October 29, 2019

Re: Patio Addition
6531 Paradise Blvd NW
Request for Certificate of Occupancy
Transportation Development Final Inspection
Engineer's/Architect's Stamp dated 7-17-19 (B10D003C2)
Certification dated 10-24-19

Based upon the information provided in your submittal received 10-24-19, Transportation Development cannot approve the release of Certificate of Occupancy for the above referenced project.

PARTIAL EXISTING SITE PLAN
1/16" = 1' - 0"

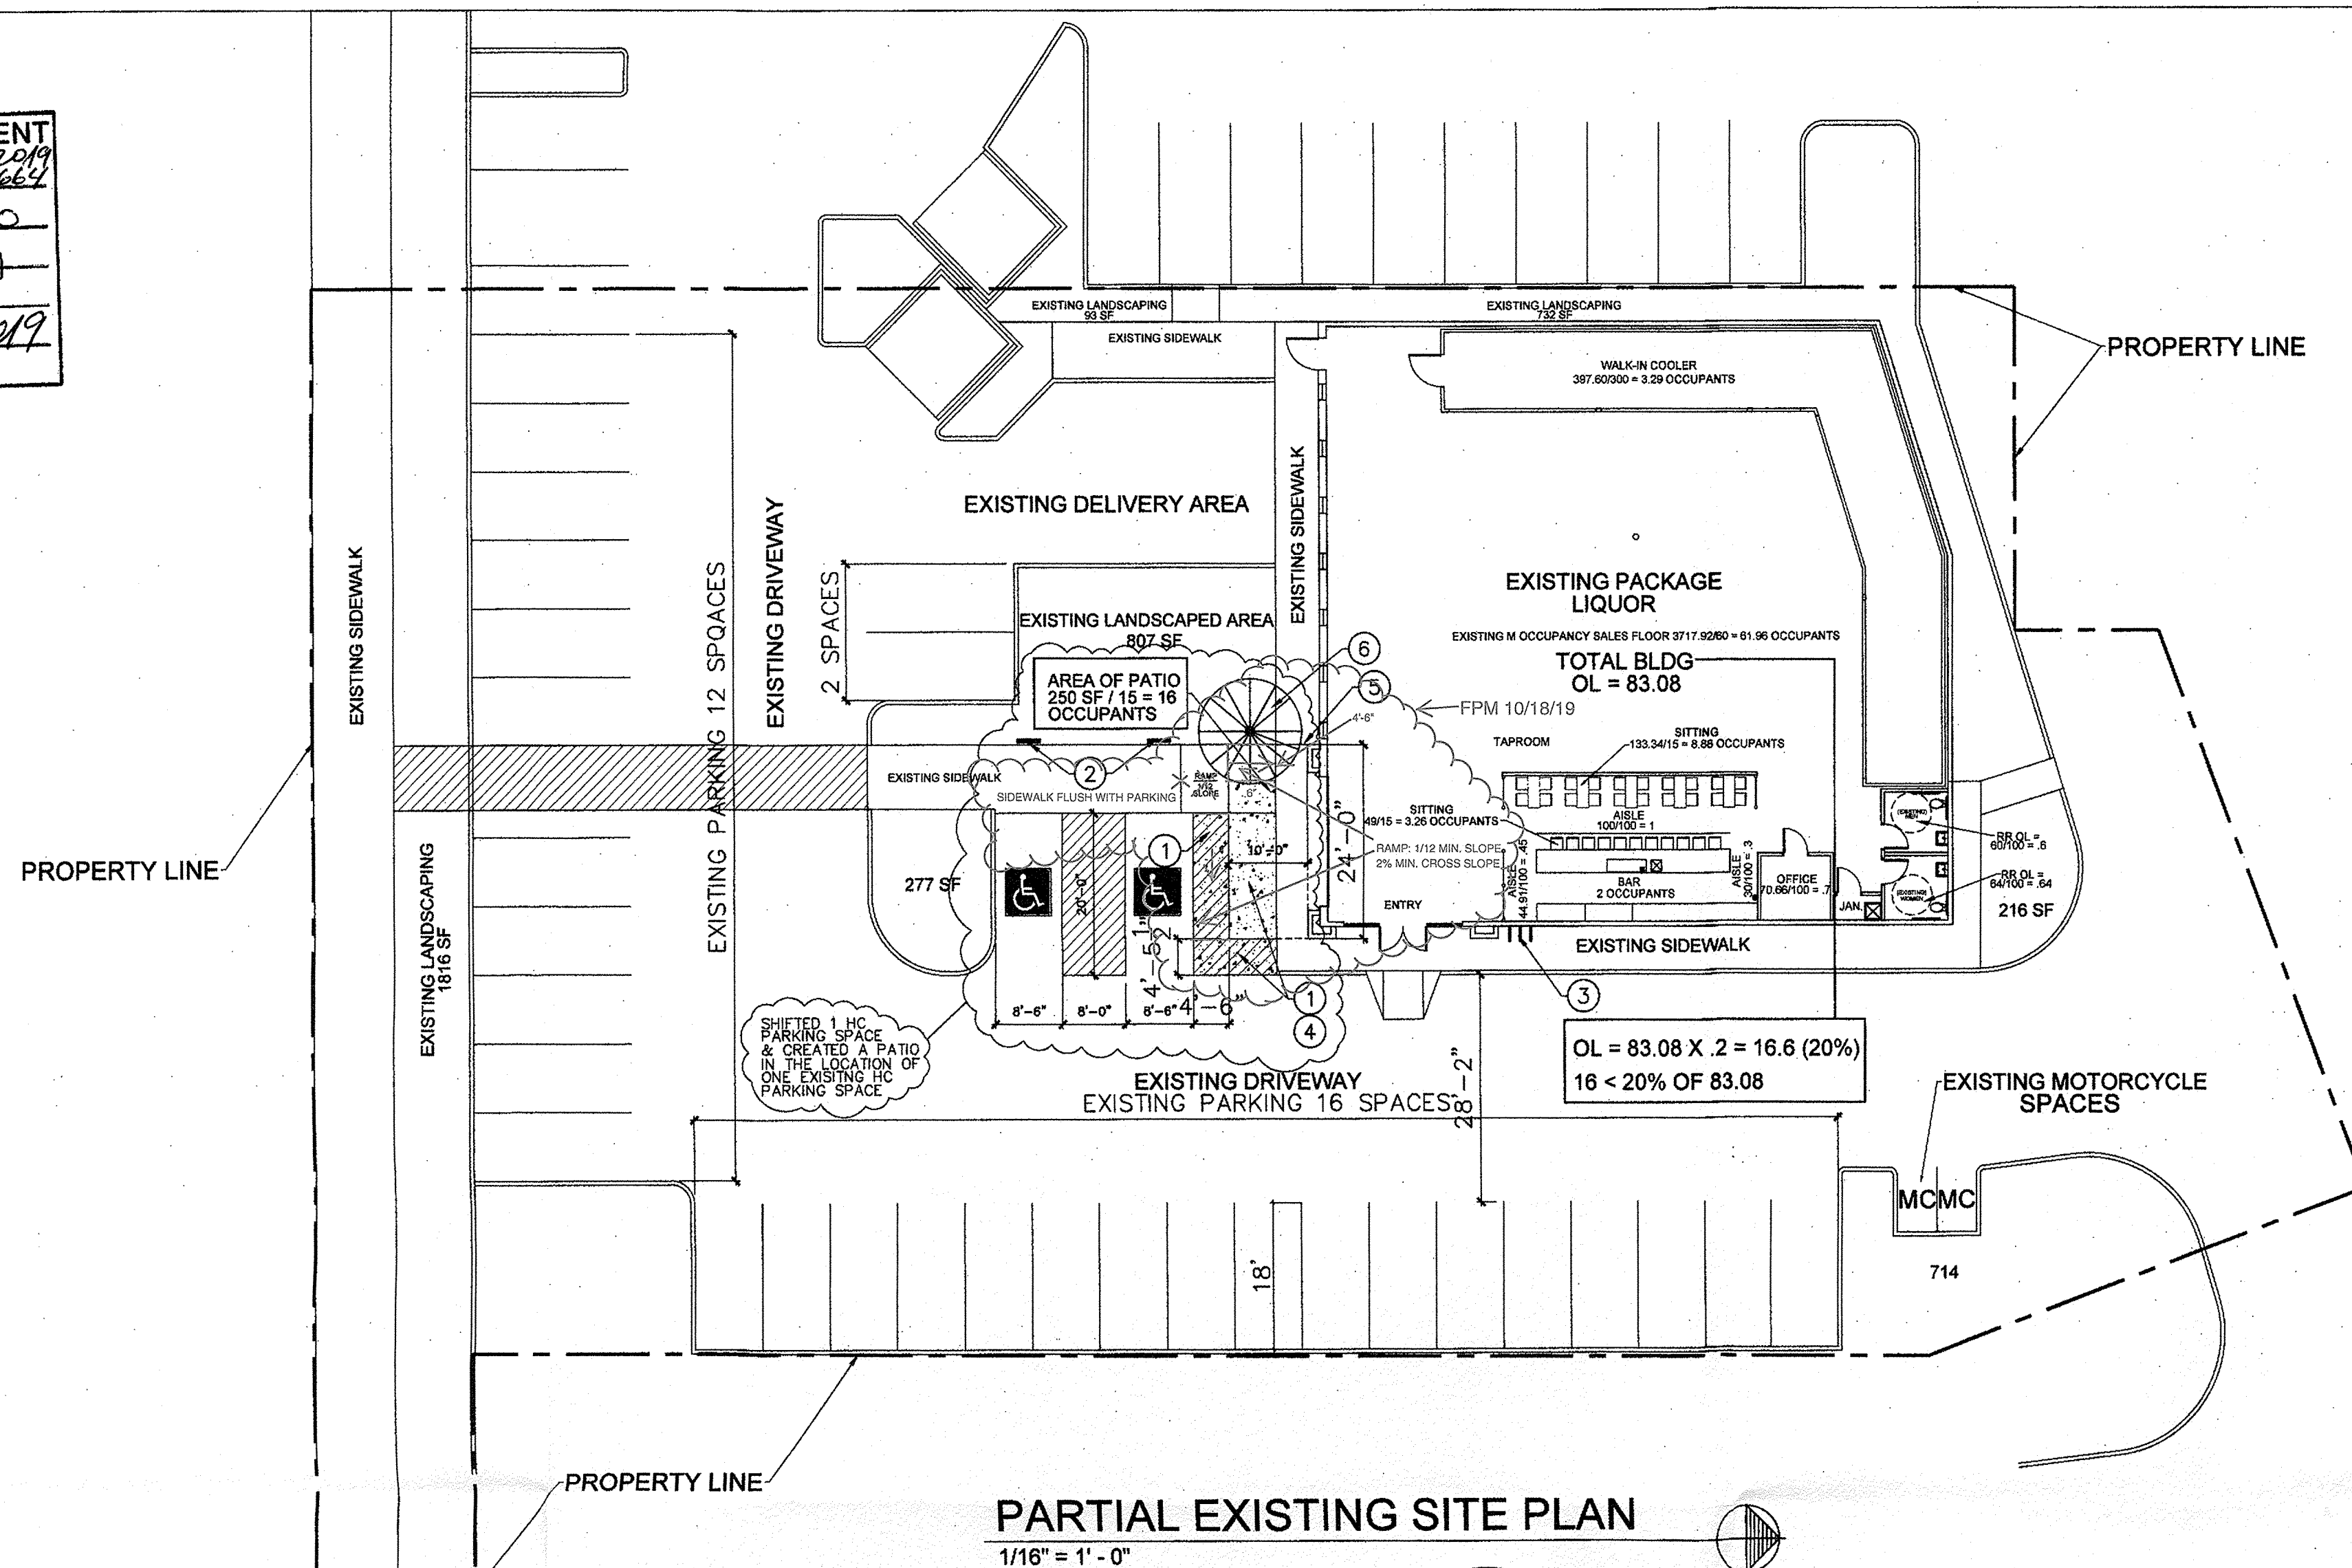
- Extension of sidewalk does not meet ADA cross slope max of 2.0% (Cross slope measured at 3.7% see attached photo)
- The ADA access aisles shall have the words **"NO PARKING"** in capital letters, each of which shall be at least one foot high and at least two inches wide, placed at the rear of the parking space so as to be close to where an adjacent vehicle's rear tire would be placed. (66-1-4.1.B NMSA 1978)
- The ADA accessible parking sign must have the required language per 66-7-352.4C NMSA 1978 **"Violators Are Subject to a Fine and/or Towing."** Please call out detail and location of HC signs.
